DEVIATION REQUEST AND DECISION FORM

Project Name : Sterling Ranch - CDR 20-005 Vollmer, Marksheffel and Sterling Ranch Rd. Construction Drawing Review
 Schedule No.(s) : 5200000364
 Legal Description : PT SE4SE4 LY S of Vollmer Rd ex RD w/ MR Sect 32-12-65 Ex Tr 2 Conv by Rec #210065613

A deviation from the standards of or in Section **ECM section 2.2.4 Roadway Functional Classifications** of the Engineering Criteria Manual (ECM) is requested for the Marksheffel Road Right of Way and cross section.

4-LANE MARKSHEFFEL ROAD  
STRIPING DETAIL  
SCALE: 1"=30'  
STA: 44+00 - 46+00

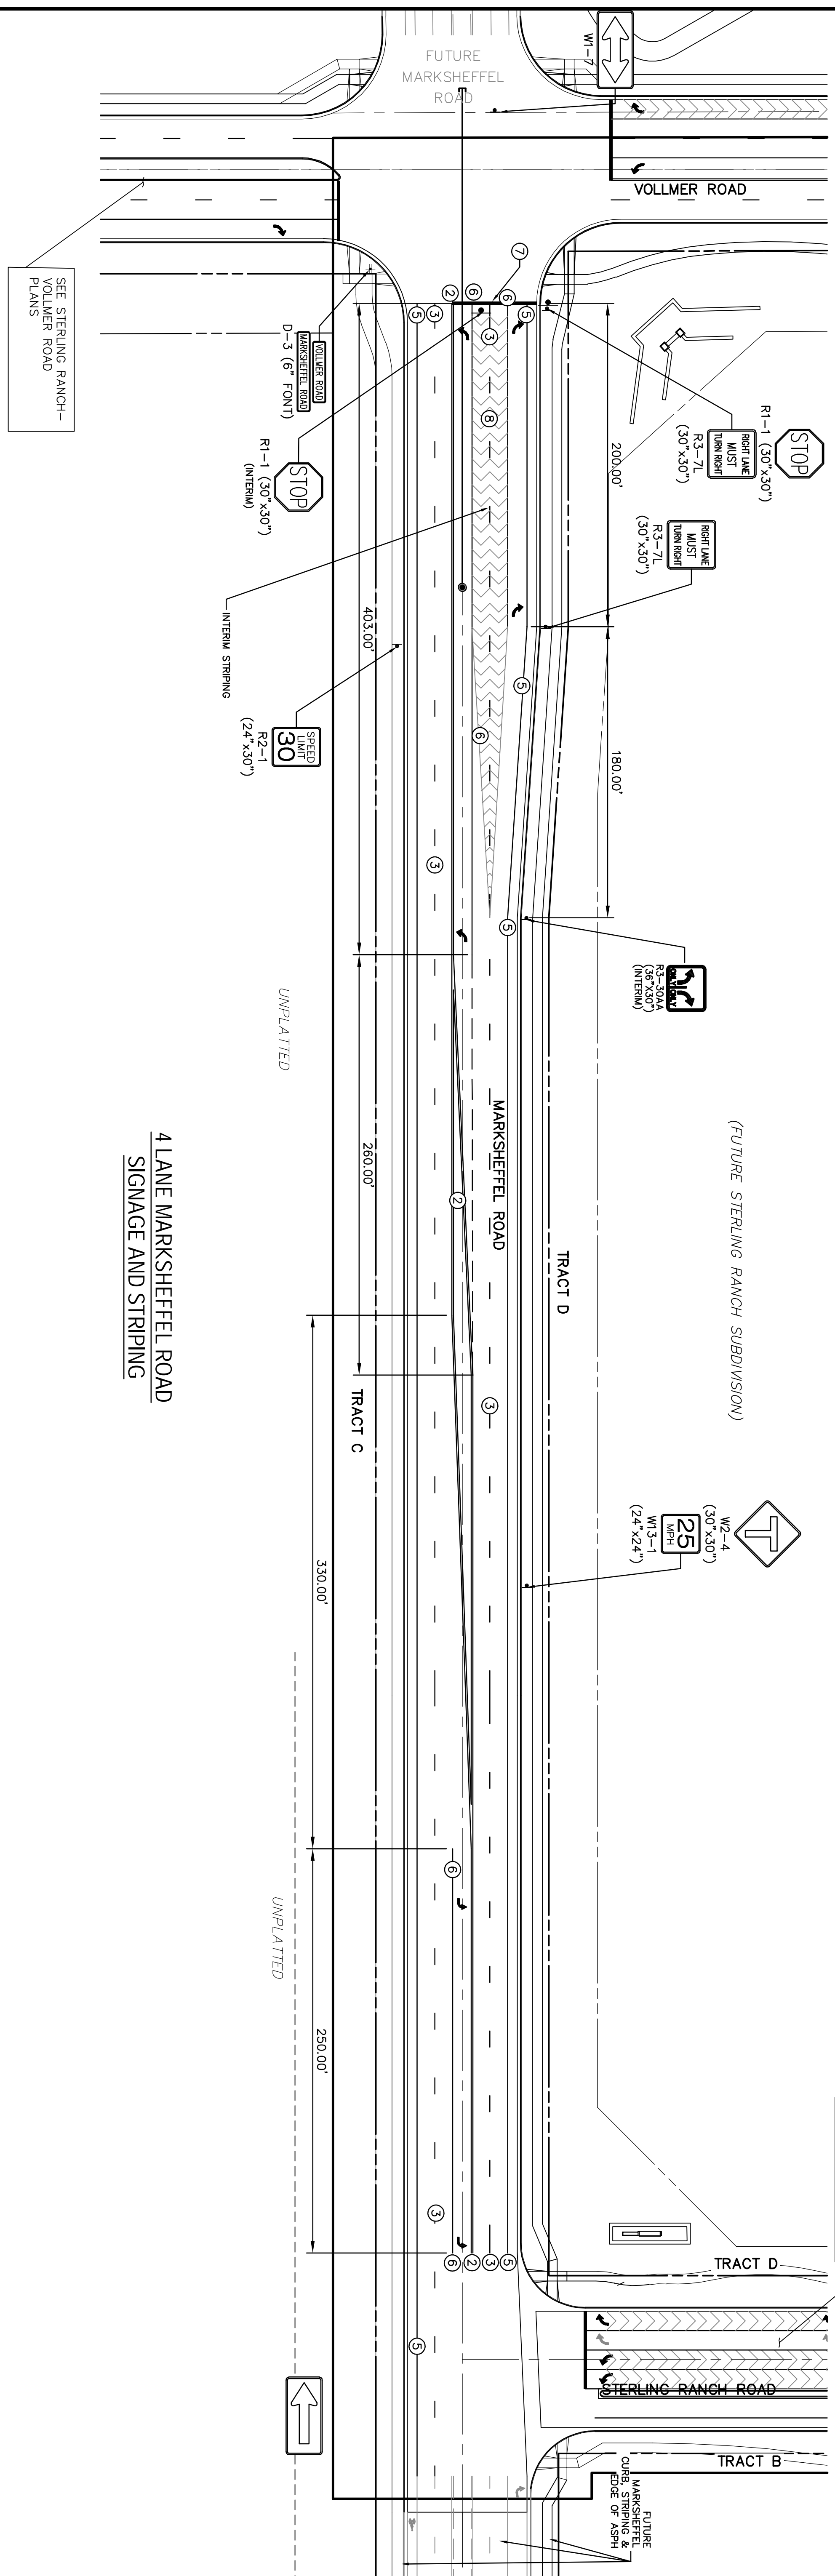
- Conditions of deviation approval:
1. El Paso County will not maintain Marksheffel road with the proposed design, and will only facilitate approvals and coordinate transfer of the road, upon completion of construction, to the City of Colorado Springs. Ultimate plan approval, notice to proceed and MS4/stormwater enforcement remains under the County’s jurisdiction until such time that the road is actually annexed into the City.

The 4 feet shoulder was approved by the previous city traffic engineer and most likely it had to do with constraints for the width of the bridge. The city standard is 6 feet shoulders for Principal Arterial, so we will require 6 feet for this stretch. The cross-section shown in your plan is acceptable, however when the city takes then ownership of this stretch of Marksheffel it will need to be fully build (not interim build).

Typically shoulders is 6' feet for this cross-section in the traffic criteria. Let us provide 6' shoulders then we can reduce the area outside of the C&G (sidewalk & landscape area) to 17'. This will still accommodate the 10' Multi-use trail and 7' landscape area in the west section.

From station 47+74 to the end of the proposed roadway within Filing 2 at station 57+65: The typical cross section of a 107 foot wide right of way. The pavement mat will be 68 ft wide providing 4 through lanes with a six foot asphalt should on each side. There will be a 12 ft. wide striped median to provide for turning movements..
